KITTITAS COUNTY DEPARTMENT OF PUBLIC WORKS

MEMORANDUM

TO: All Staff
FROM: Public Works Plan Review Team
DATE: May 23, 2024
SUBJECT: SX-24-00008 Gray

1 ARCHITECTURAL SITE PLAN  
SCALE: 1:60

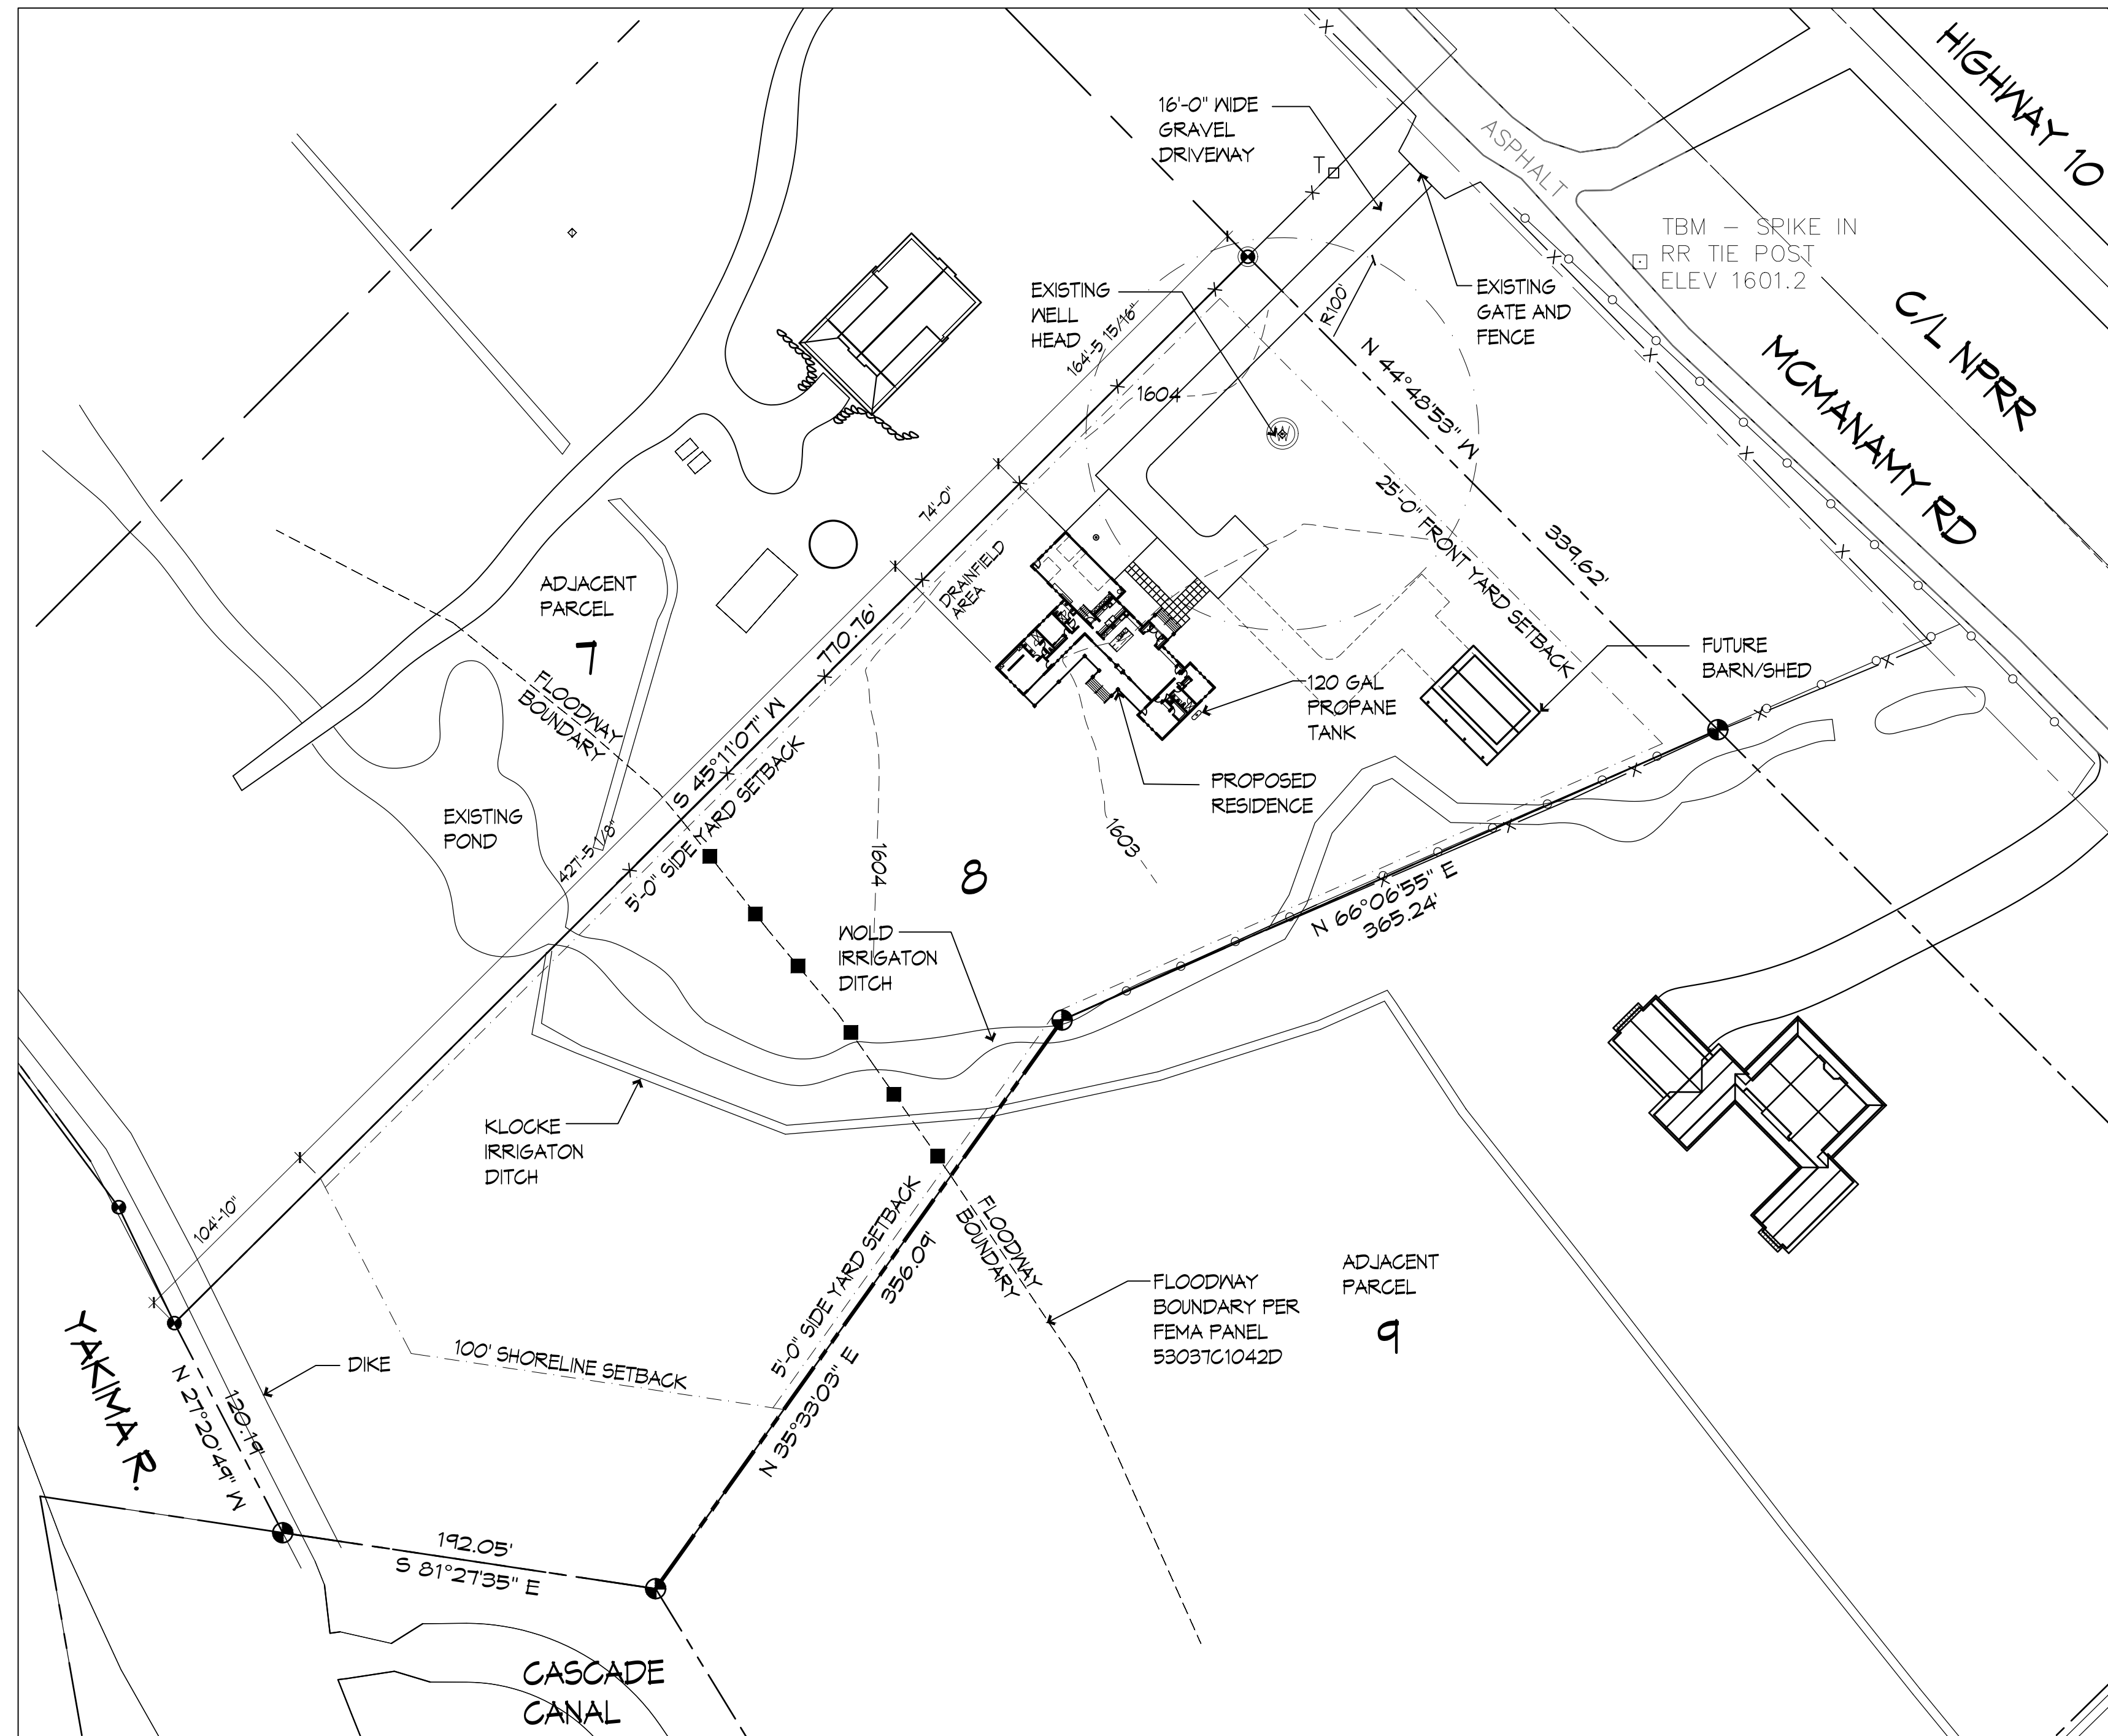
ENGINEERING	Except as exempted in KCC 14.05.060, no grading or filling upon a site involving more than one hundred (100) cubic yards shall be performed without a grading permit from the County Engineer or Public Works designee (KCC 14.05.050). An application for grading in excess of five hundred (500) cubic yards shall be accompanied by an engineered grading plan (KCC 14.05.080).
FLOOD	<p>The proposed development requires a floodplain development permit and must meet KCC 14.08 requirements. Public Works has received a floodplain development application for the project that is under review (FD-24-00012).</p> <p>The parcel contains FEMA designated Floodway. Per the submitted site plan, the proposed single-family residence is located outside the Floodway. Please be advised that the Floodway is highly restricted and any development within the floodway must be permitted through a floodplain development permit and must demonstrate no rise of 100-year flood elevations before being permitted. No new or substantially improved residences are allowed within the Floodway. (SC)</p>
